Santa Sophia Catholic College Modification 1

External design amendments, changes to café operational hours and amendments to reporting conditions
State Significant Development Modification Assessment
(SSD 9772 MOD 1)

October 2020

Published by the NSW Department of Planning, Industry and Environment

DRIVEWAY PLAN
SCALE 1: 100

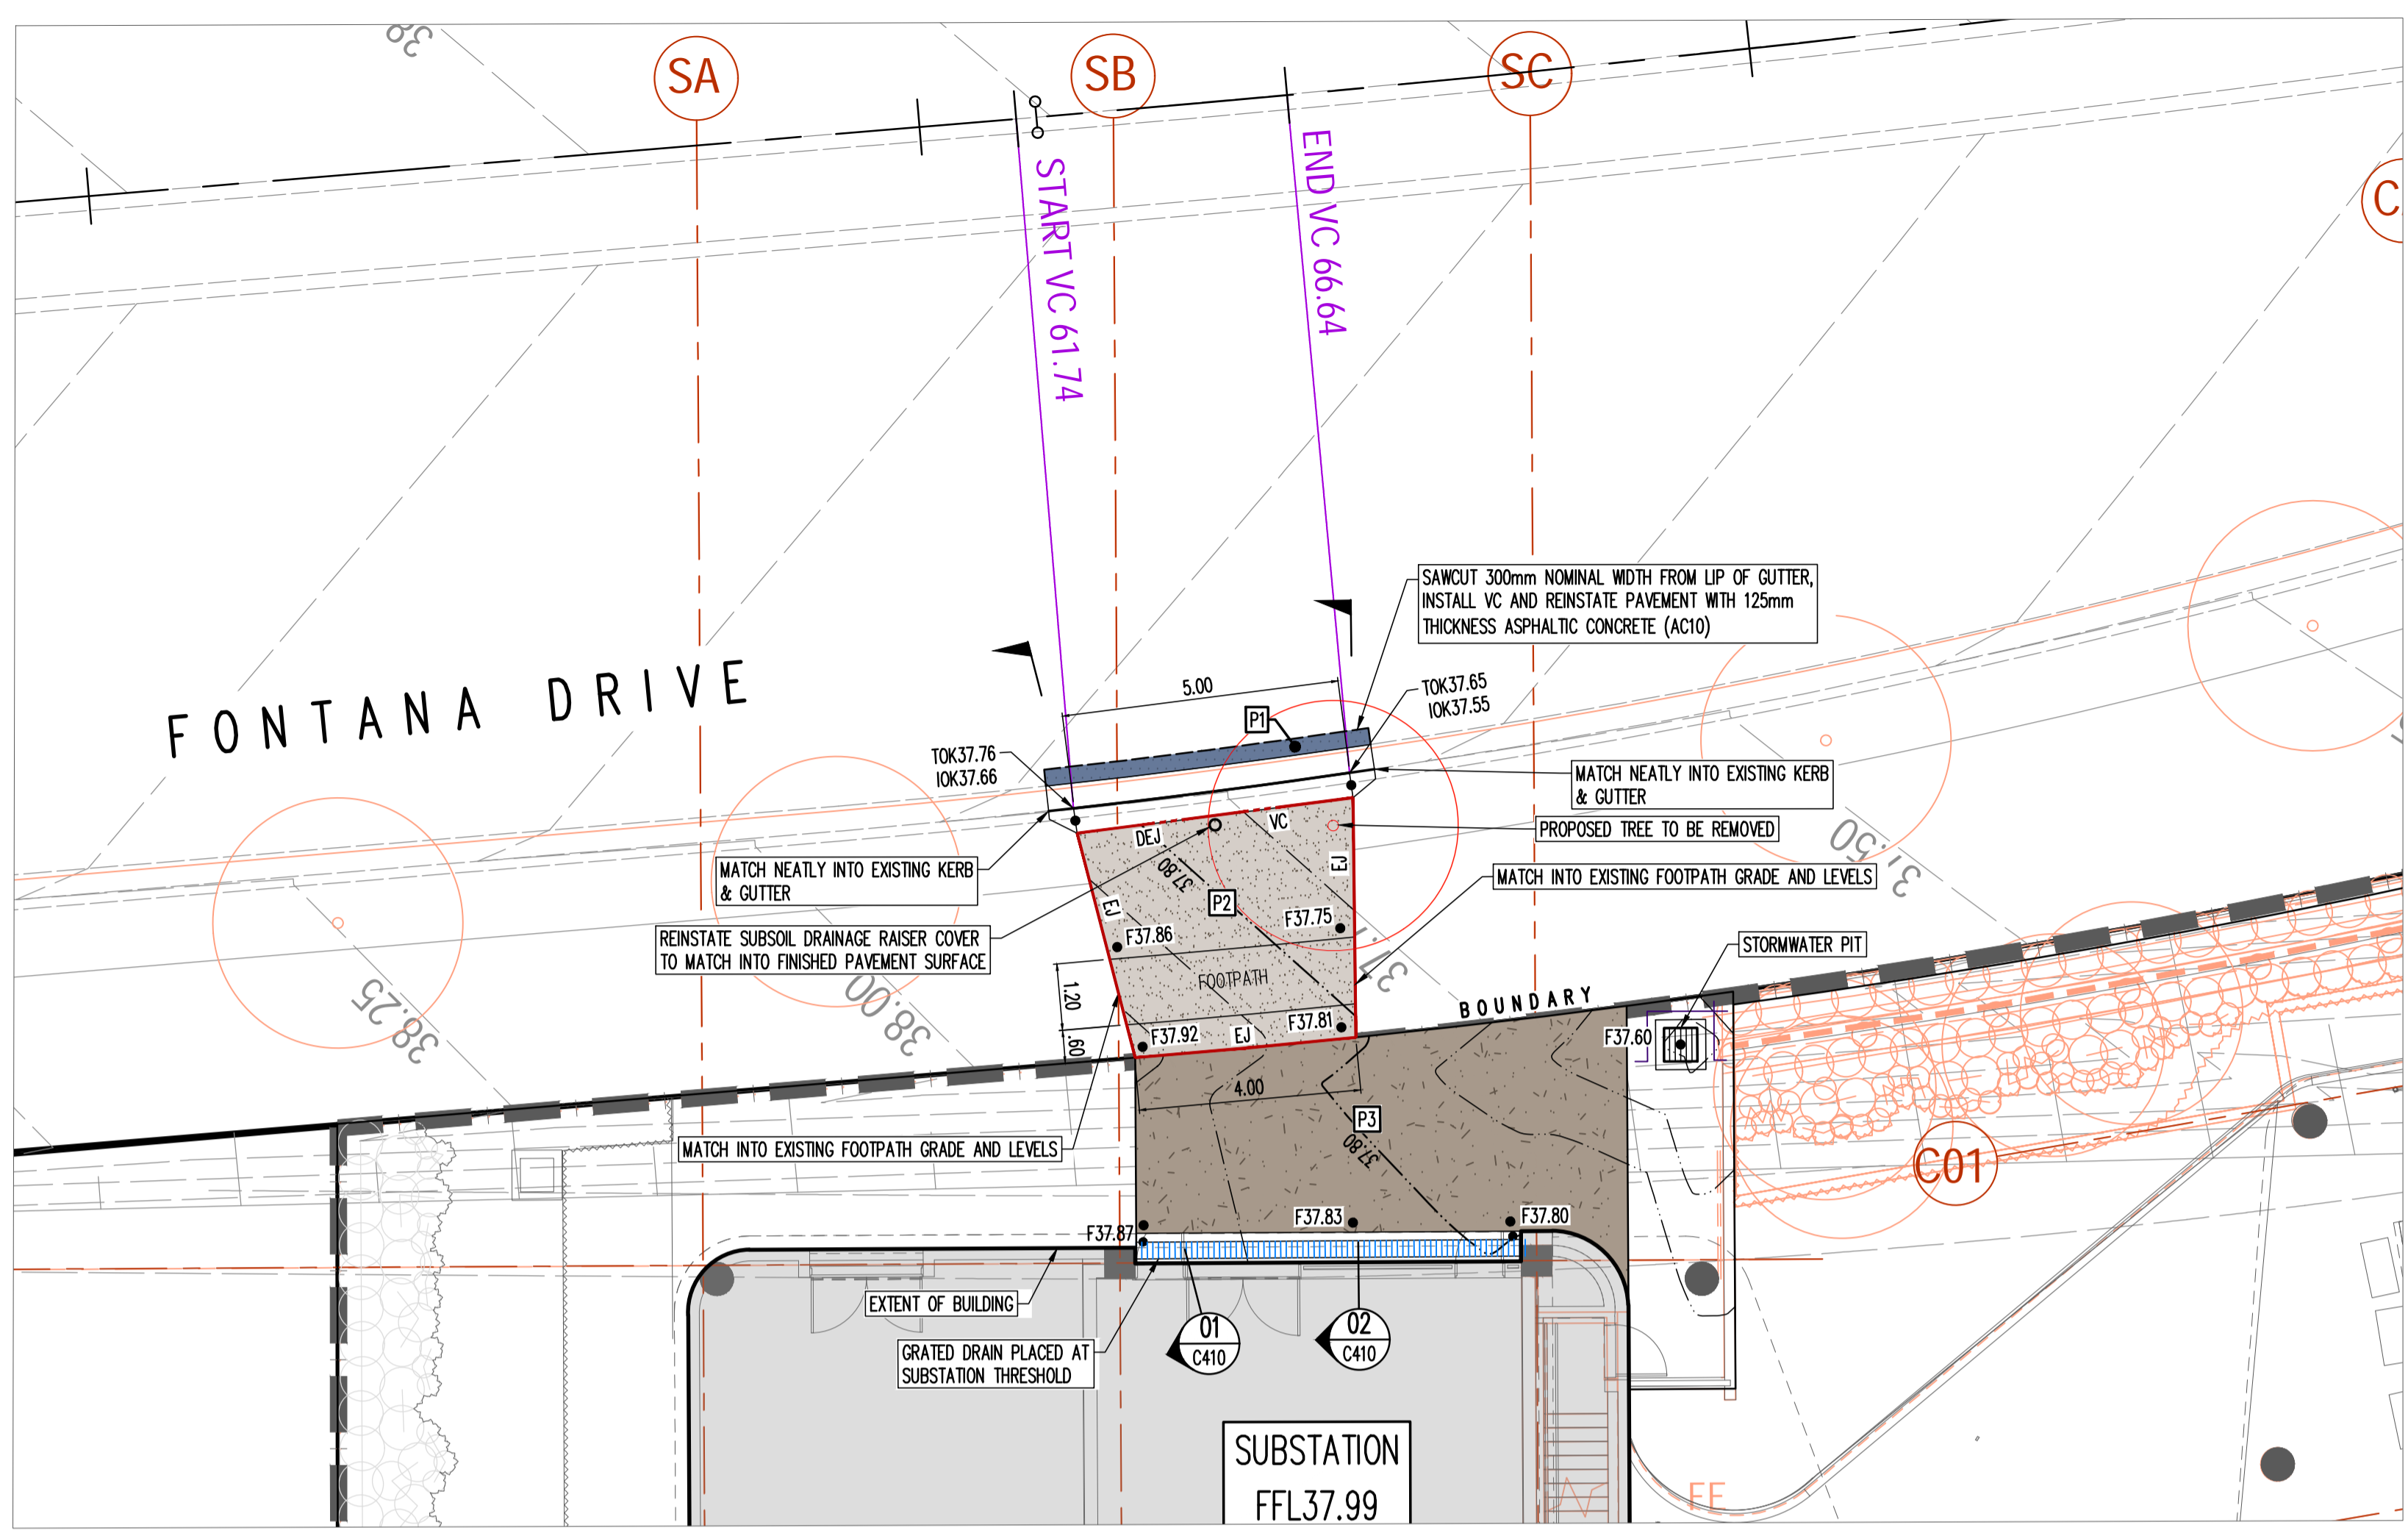
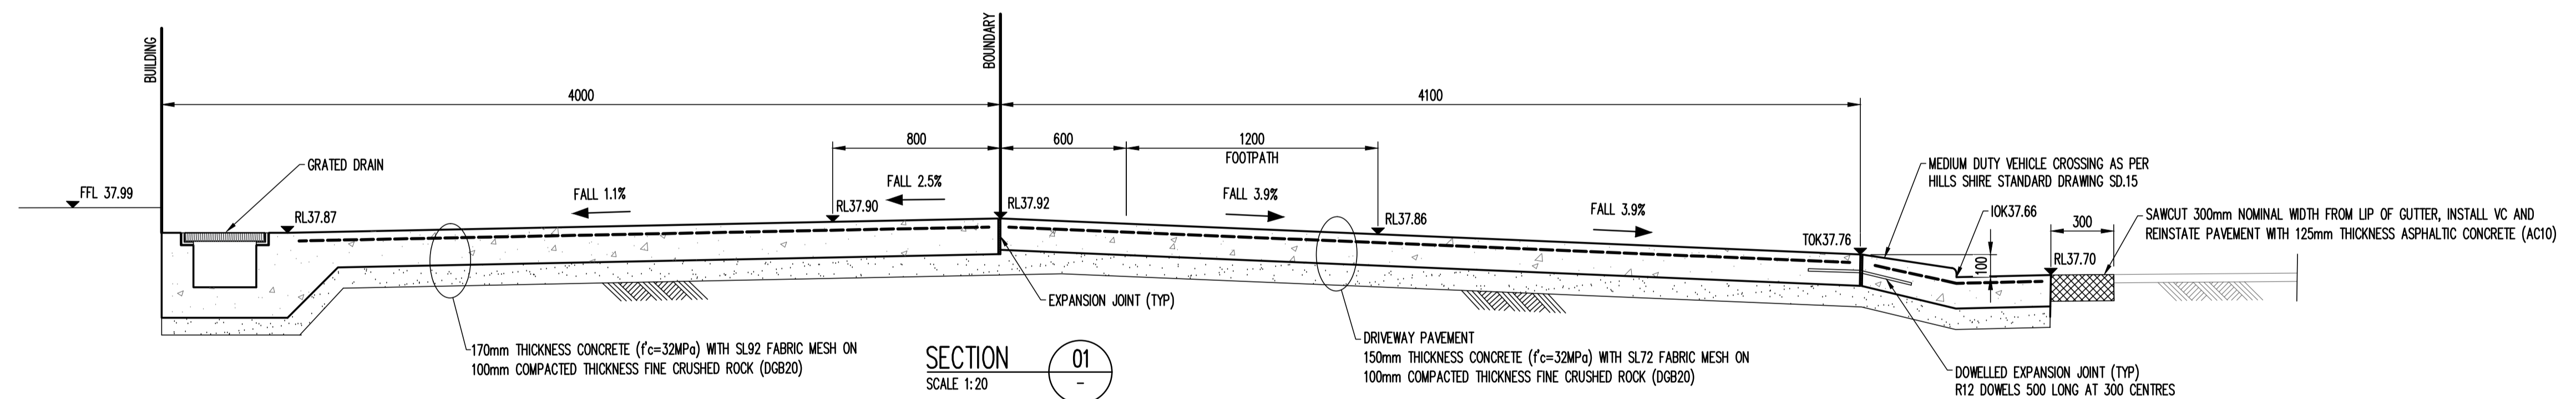
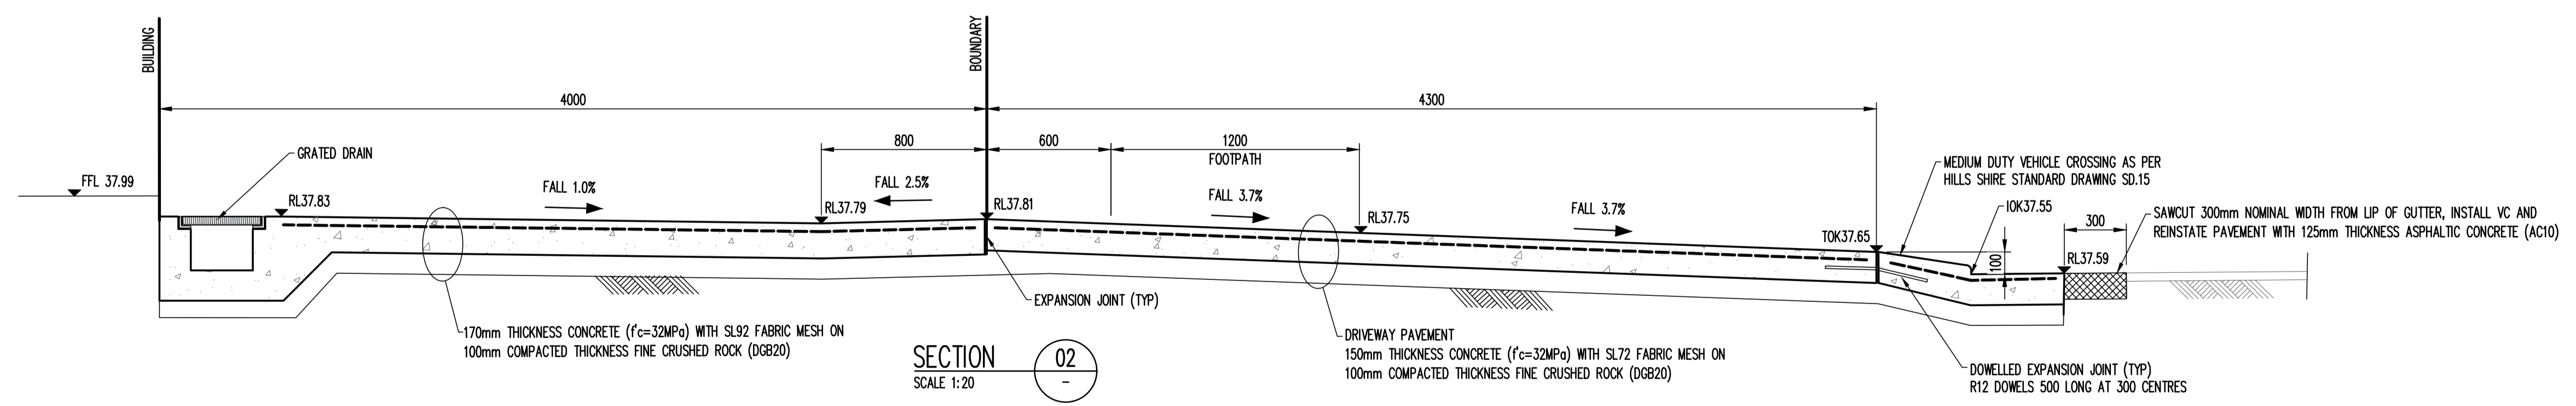
- the reversing movement on future Fontana Drive is not encouraged from a safety perspective as the proposed crossing would be in proximity to the signalised intersection of future Fontana Drive / Red Gables Road. However, Council conceded that due to infrequent truck movements on this driveway, this can be supported subject to suitable traffic control measures via the Road Occupancy Licence.
- the application refers to the vehicle protruding into the carriageway within the "parking lane of Fontana Drive" however this lane is for turning and not for parking.

The proposed modification would result in two minor concrete pavements and two vehicular crossings off future Fontana Drive and off future Road B. Swept path analysis has been provided with the proposal which identifies that the trucks accessing the substation would have to complete a reversing maneuver on to the future Fontana Drive to reverse on to the vehicular crossing for loading / unloading.

Council reviewed the applicant's Modification Report and commented that reversing movement on future Fontana Drive is not encouraged from a safety perspective as the proposed crossing would be in proximity to the signalised intersection of future Fontana Drive / Red Gables Road. However, Council also noted that due to infrequent truck movements on this driveway, this can be supported subject to suitable traffic control measures and the provision of suitable traffic controls via the Road Occupancy Licence (with approvals via Council's Traffic Committee). Council did not raise concerns regarding turning movements on future Road B.

The Department has reviewed the swept path analysis and Council's comments. While the Department agrees with Council that reversing movements may result in unsafe traffic environment, the Department notes that the future Fontana Drive would be a local road and not a collector / classified road. Consequently, a truck could reasonably reverse on to this road on an infrequent basis as proposed by the Applicant. The Department considers that the safety issues raised by Council for the use of the vehicular crossing on future Fontana Drive can be mitigated through suitable traffic controls. Conditions to this effect have been recommended requiring additional details in the approved Operational Traffic and Access Management Plan and a Road Occupancy Licence (where needed). Additional conditions of consent have also been recommended requiring the Applicant to obtain separate construction certificates for the driveway crossings from Council.
